From: Chris Pirone
To: Jean Fraser
Date: 4/10/2014 4:42 PM
Subject: Fwd: RE: 118 on Munjoy Hill - Revised Construction Management Plan

From: Jean Fraser [mailto:JF@portlandmaine.gov]
Sent: Wednesday, April 09, 2014 2:59 PM
To: Bourke, Jeanie; Machado, Ann; Stanley, Virginia
Cc: Bergeron, Rick; Carey, Tom; Greer, Tom; Lloyd, David; Newell, Chip; Pitman, Cordelia
Subject: Re: 118 on Munjoy Hill - Revised Construction Management Plan

DPS have the following comments on the CMP letter and plan submitted April 1, 2014 - please note that Tom Errico, Traffic Engineering reviewer, Captain Chris Pirone of the Fire Department, and John Peverada, Parking Manager, all concur with these comments:

On January 28th, 2014 the Portland Planning Board requested nine (9) conditions of approval of a Level III Final Site Plan and Subdivision proposal for "118 on Munjoy Hill" Condominium 12 unit residential, and 2 unit commercial, condominium #2013-255 located at 118 Congress Street . CBL:16-D-2

Project Schedule

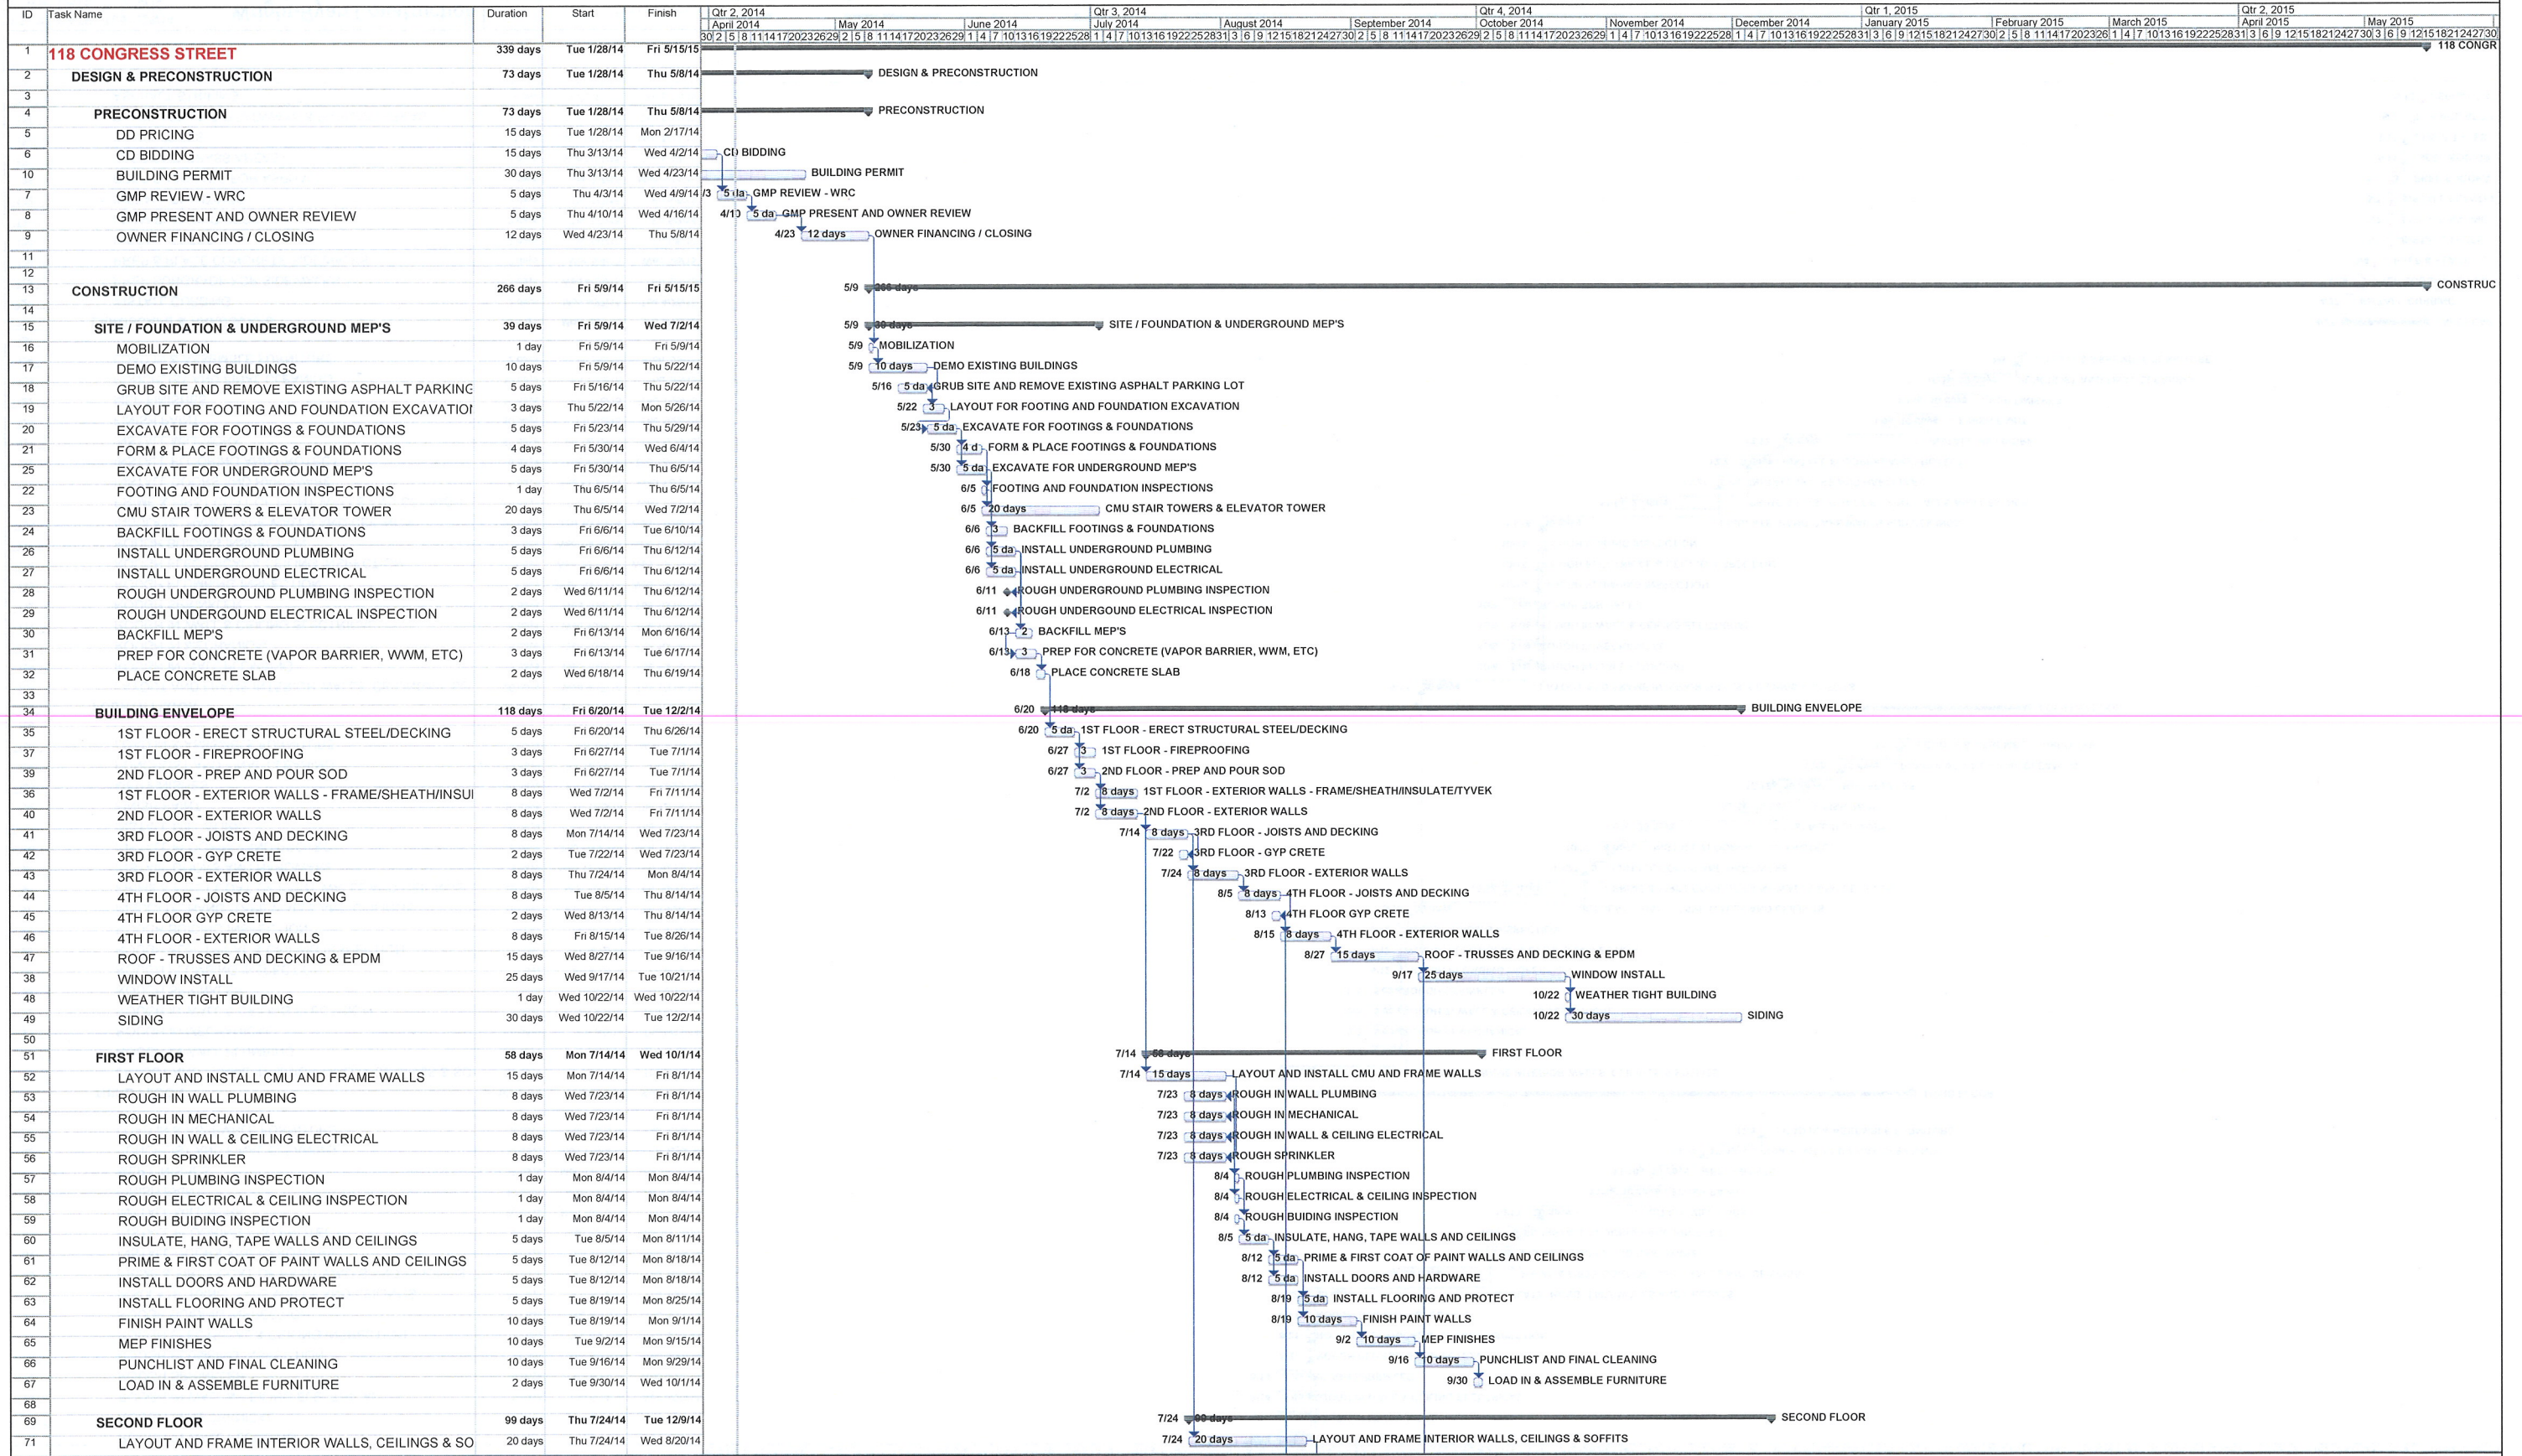
The Schedule as submitted could not be opened and the re-formatted version has been circulated today- I don't expect to get any further comments but wanted you to be aware that the schedule has not been reviewed.

Construction Management Plan

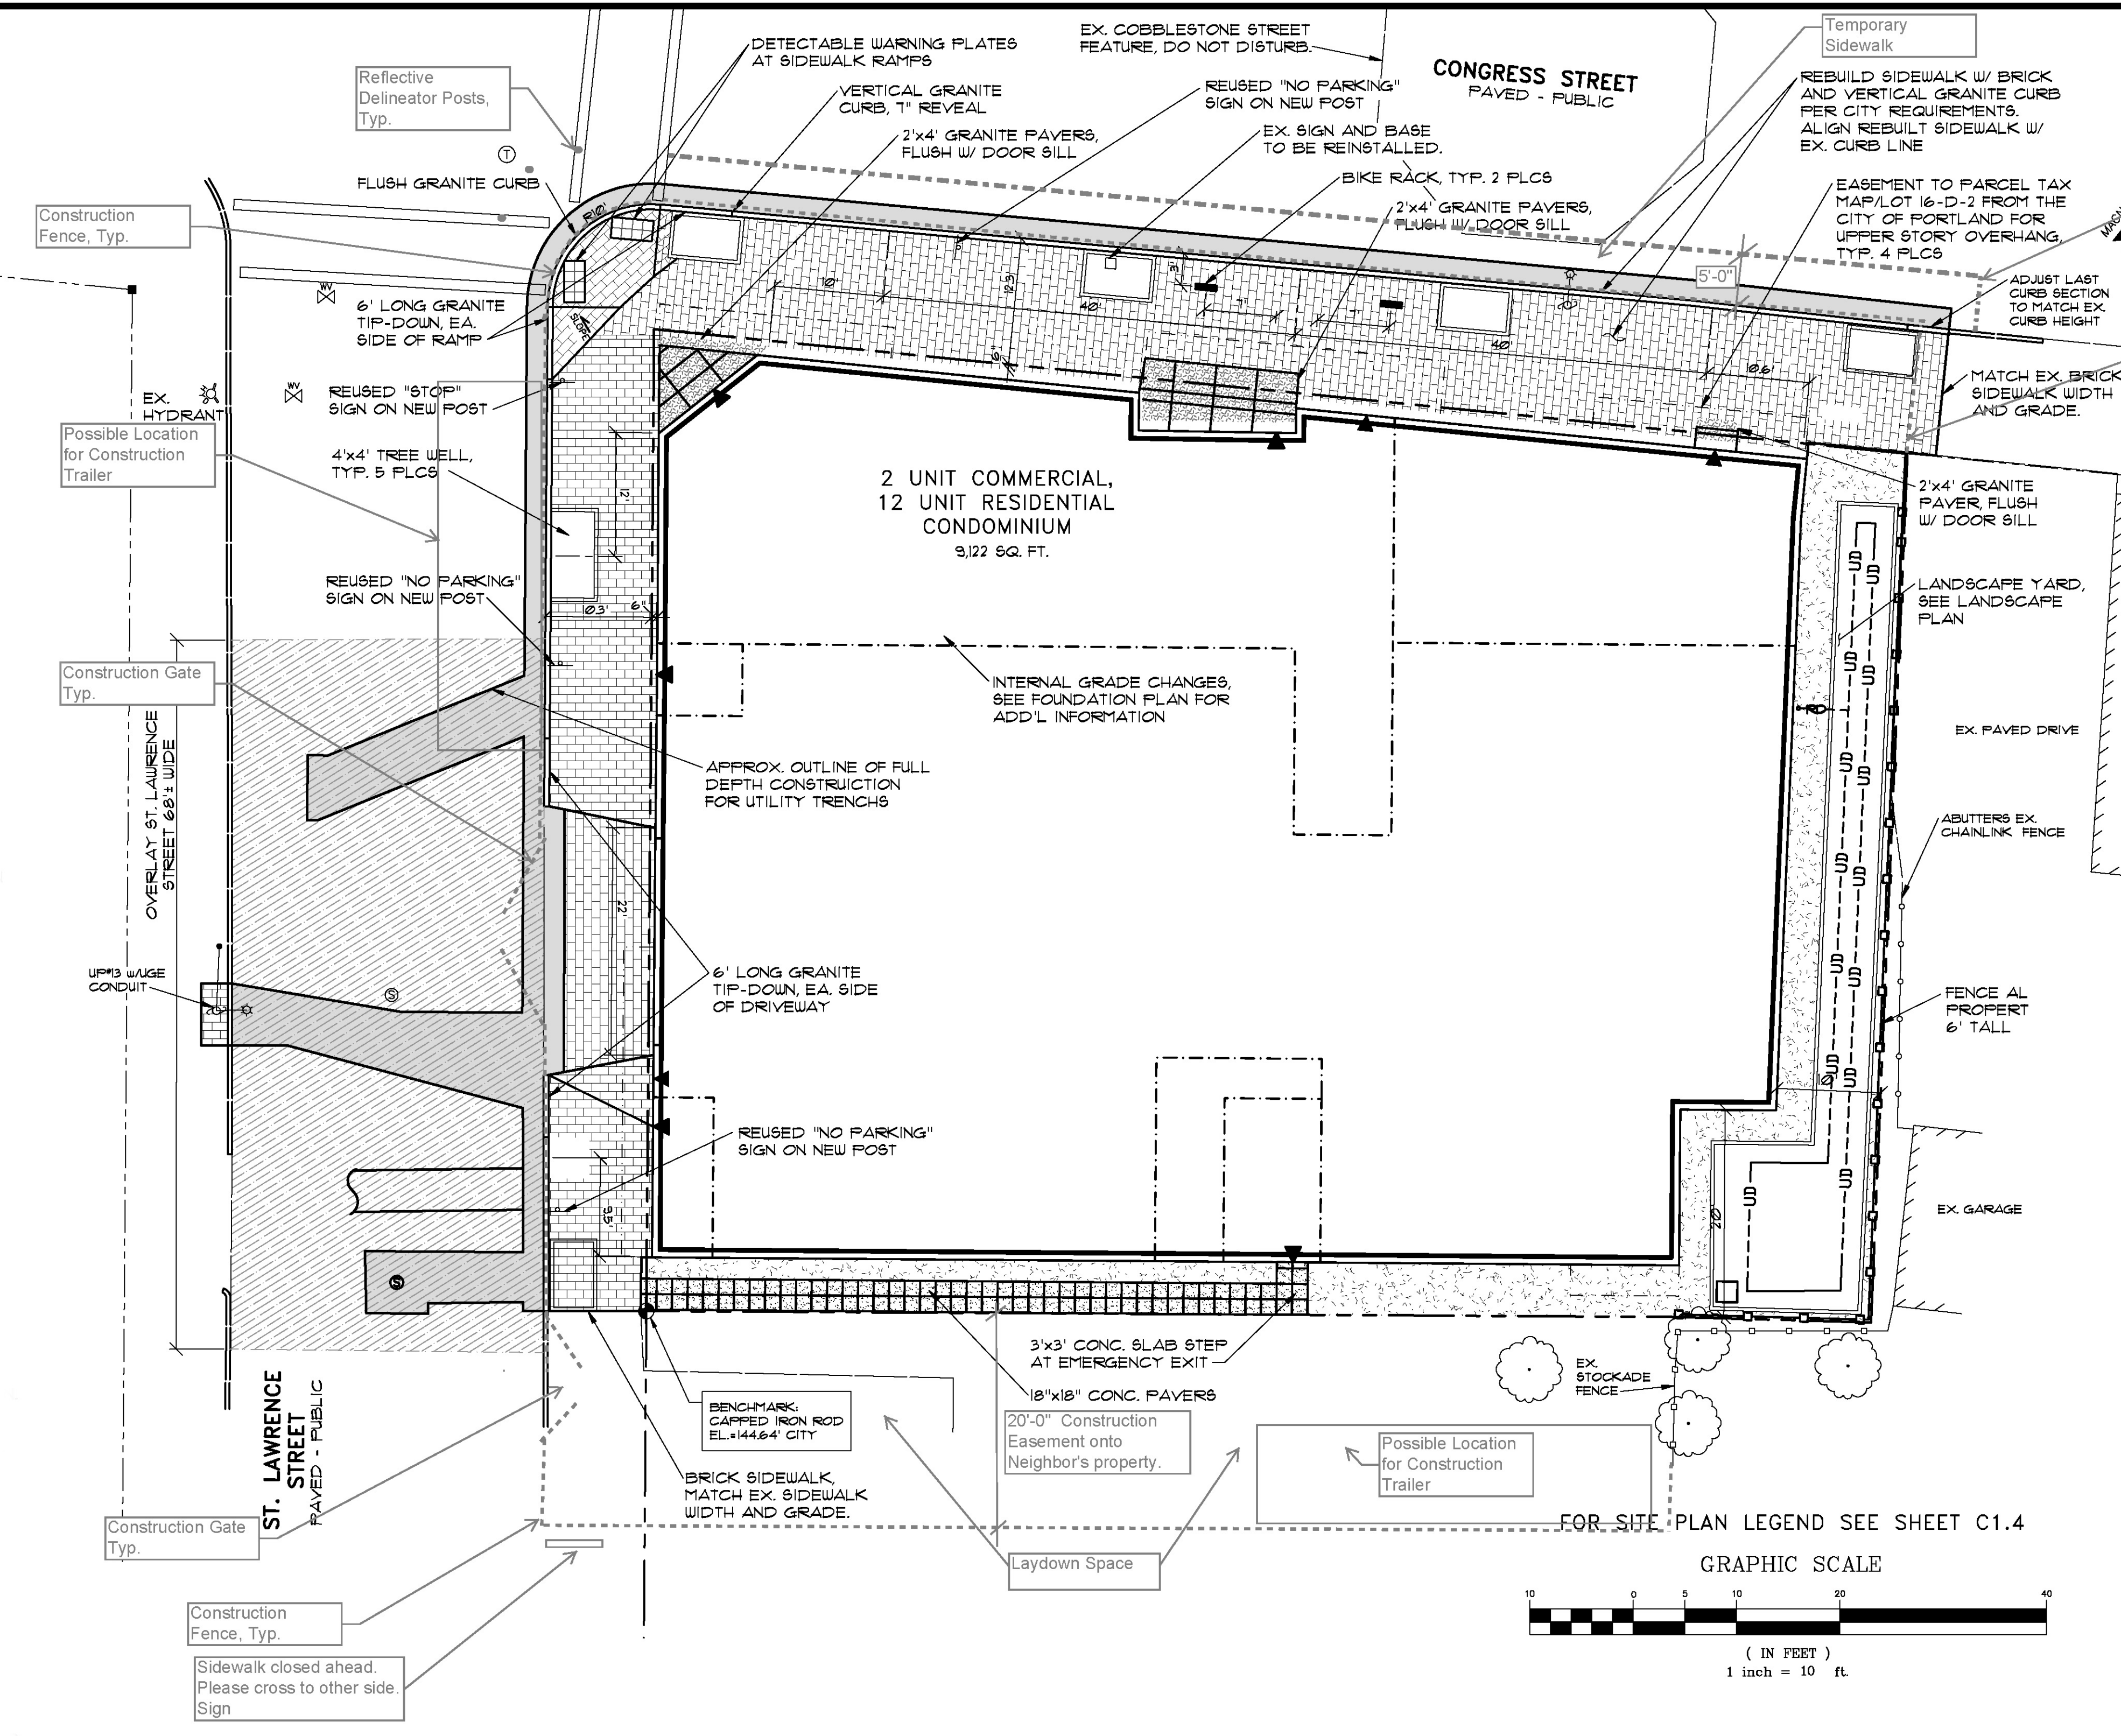
We would like the applicant to eliminate the proposed mid-block "temporary crosswalk" on St. Lawrence St and post a "Sidewalk Closed Ahead - Cross Here" sign at the intersection of Monument and St Lawrence; The proposed temporary sidewalk layout (Congress Street) is acceptable to Public Services but will occupy approximately four parking spots on Congress Street. One is a U-Haul Car Share spot. At least one week before the temporary sidewalk is installed, the developer will need to work with John Peverada to relocate the Car Share location. Since four parking locations will be occupied, there will be a \$15/day or \$420 fee per week for occupying these parking spots.

Please revise the plan as requested - also it would be easier if the notes in the letter were added to the plan where not already identified, so all the information is on one plan. Please send the final version of the CMP to me so I can get a final "sign off" and confirm to you that the condition has been met.

Attached please find a revised Construction Management Plan dated 4/10/14. Wright Ryan Construction incorporated the changes requested in your email below.
